RE: Monument Ridge – Retail Paint Store Final PUD Plan

Your Final PUD Plan for Monument Ridge – Retail Paint Store has been reviewed by outside agencies and Town Staff. Comments and necessary revisions have been compiled and are provided below. Some items are summarized in the interest of being concise and clear. Names and contact information are provided should you need to discuss any of the comments with the specific reviewer. Town comments are provided at the end of the letter; duplicate comments have been removed for your convenience. There may be additional comments/revisions as a result of your response to this first round of comments. We are happy to discuss any of these items, if necessary.

3 OF 10

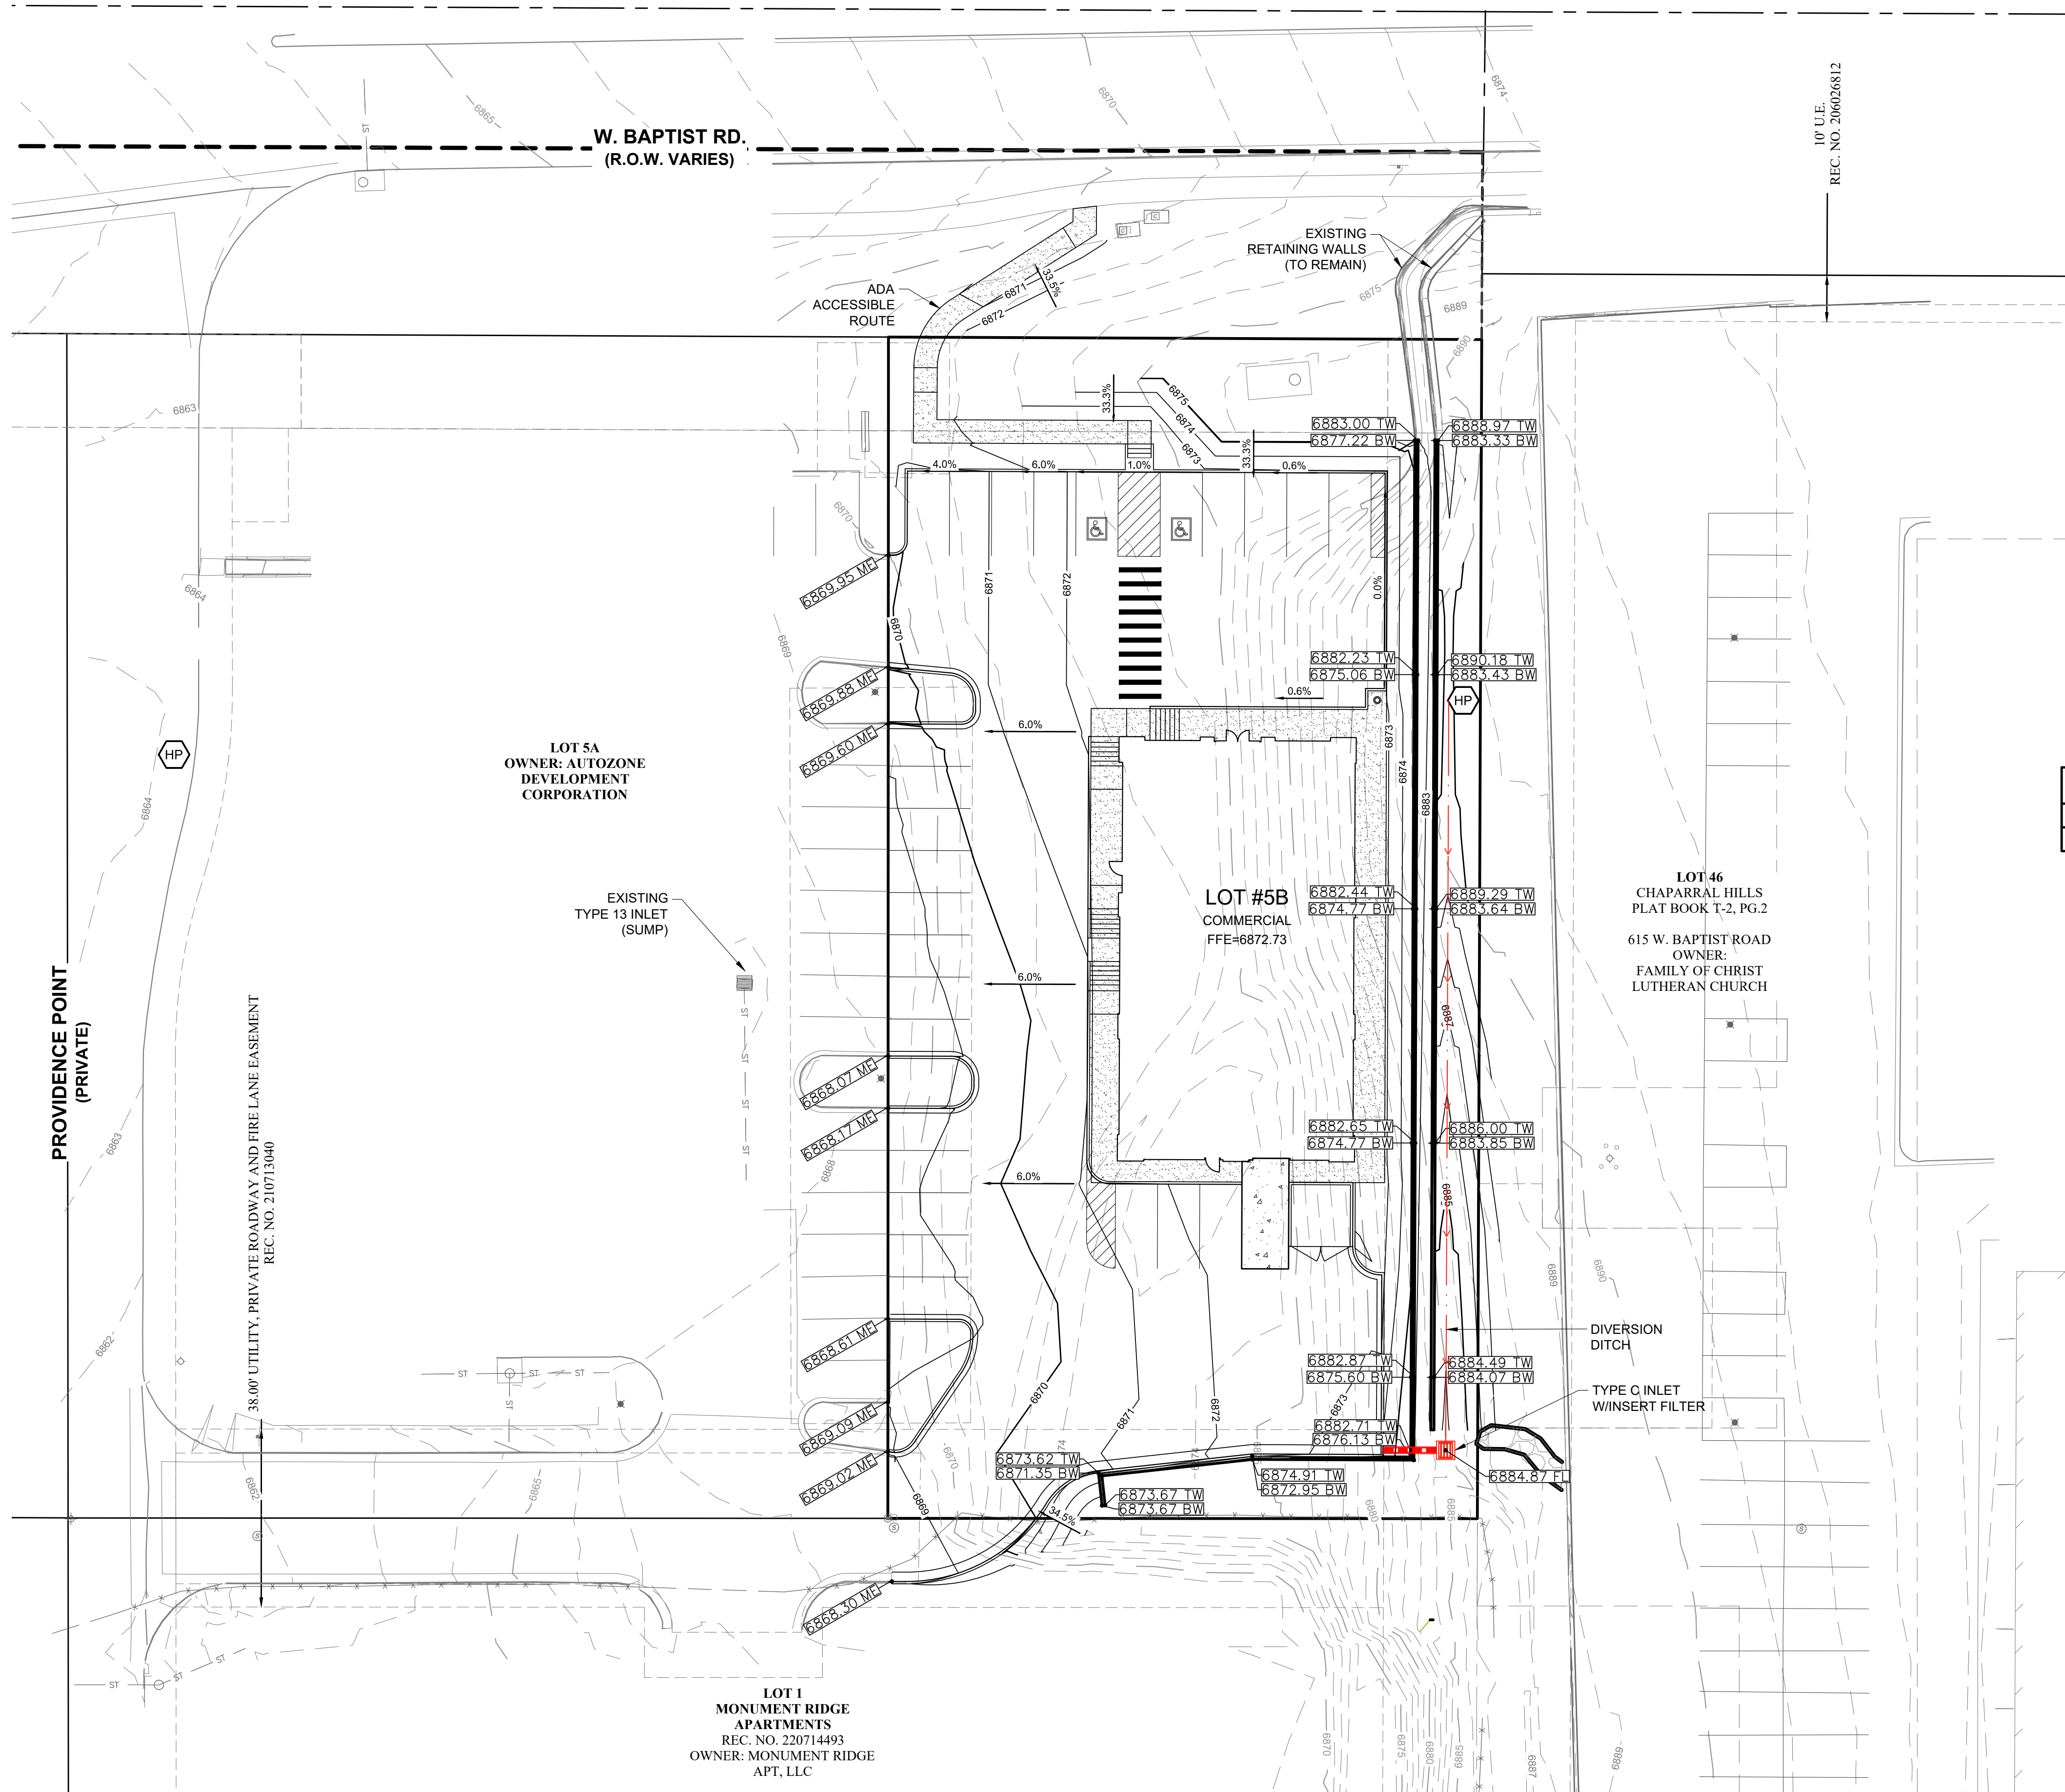
1. The two legends should identify the property line consistently with the plan and other sheets.

2. A symbol is missing in the Legend for Proposed Site Lighting.

3. Legend items including traffic flow, ADA route and proposed sign(s) should be added to the plan.

4. Detailed grading will be required on the Construction Documents. The following areas are noted on the preliminary grading plan:

- a. A 12"+ curb height is indicated along the west building sidewalk.
EES Response: Grading revised, there is no longer a 12"+ curb height..
- b. Clarity for drainage at the northwest parking lot edge, and along the southwest access drive curb line.
EES Response: Acknowledged, to be provided in CDs.

- c. ADA route details (ramps, landings, etc.).
EES Response: Acknowledged to be provided in CDs.
- d. Grading for the diversion ditch east of the retaining wall extends onto the adjoining property. An easement or other documentation of permission should be obtained.
EES Response: Revised to stay with property boundary.

- e. Off-site diversion ditch grading to the proposed Type C inlet, including graded sump.
EES Response: Acknowledged, to be provided in CDs.
- 5. Type of retaining walls should be identified.
EES Response: Acknowledged, to be provided in CDs.

- 6. The Drainage Plan identifies an 18" storm pipe in the adjoining Monument Ridge Apartments tract to the south. This should be added to this sheet. Is the storm pipe existing or proposed?
EES Response: This pipe was never constructed by the apartments.

- 7. Construction and maintenance of the off-site diversion ditch and Type C inlet will need to be coordinated with the owner of Lot 1 Monument Ridge Apartments (including the 18" storm pipe if it has not yet been installed).
EES Response: Diversion ditch and Type C inlet are now all contained within the property boundary.

EES Response: Revised.

EES Response: Revised.

EES Response: Traffic flow removed from legend, ADA route and proposed signs added.

Figure 3.4.2-2. CDOT Type 13 Combination inlet interception capacity in a sump

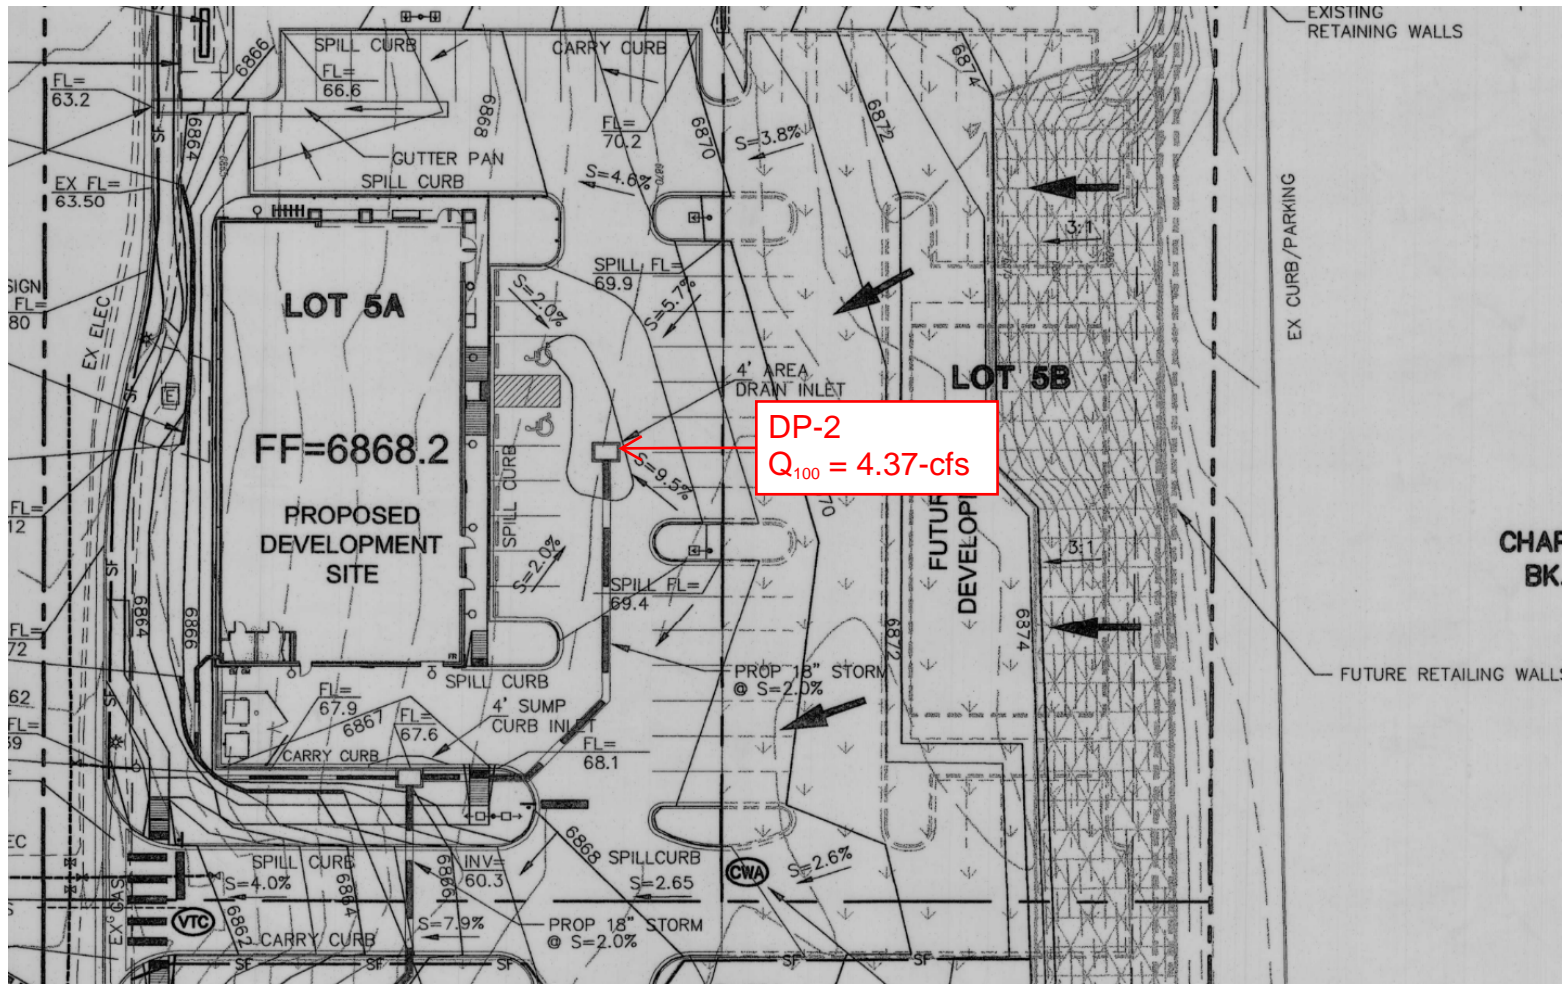
5. Figure 3.4.2-2. on pdf page 40 refers to a Type 13 “combination inlet,” whereas the existing parking lot inlet appears to be simply a Type 13 with valley grate. Actual capacity of this inlet should be confirmed.

EES Response: This is correct, the inlet is a valley grate, not a combination inlet. Capacity calcs revised.
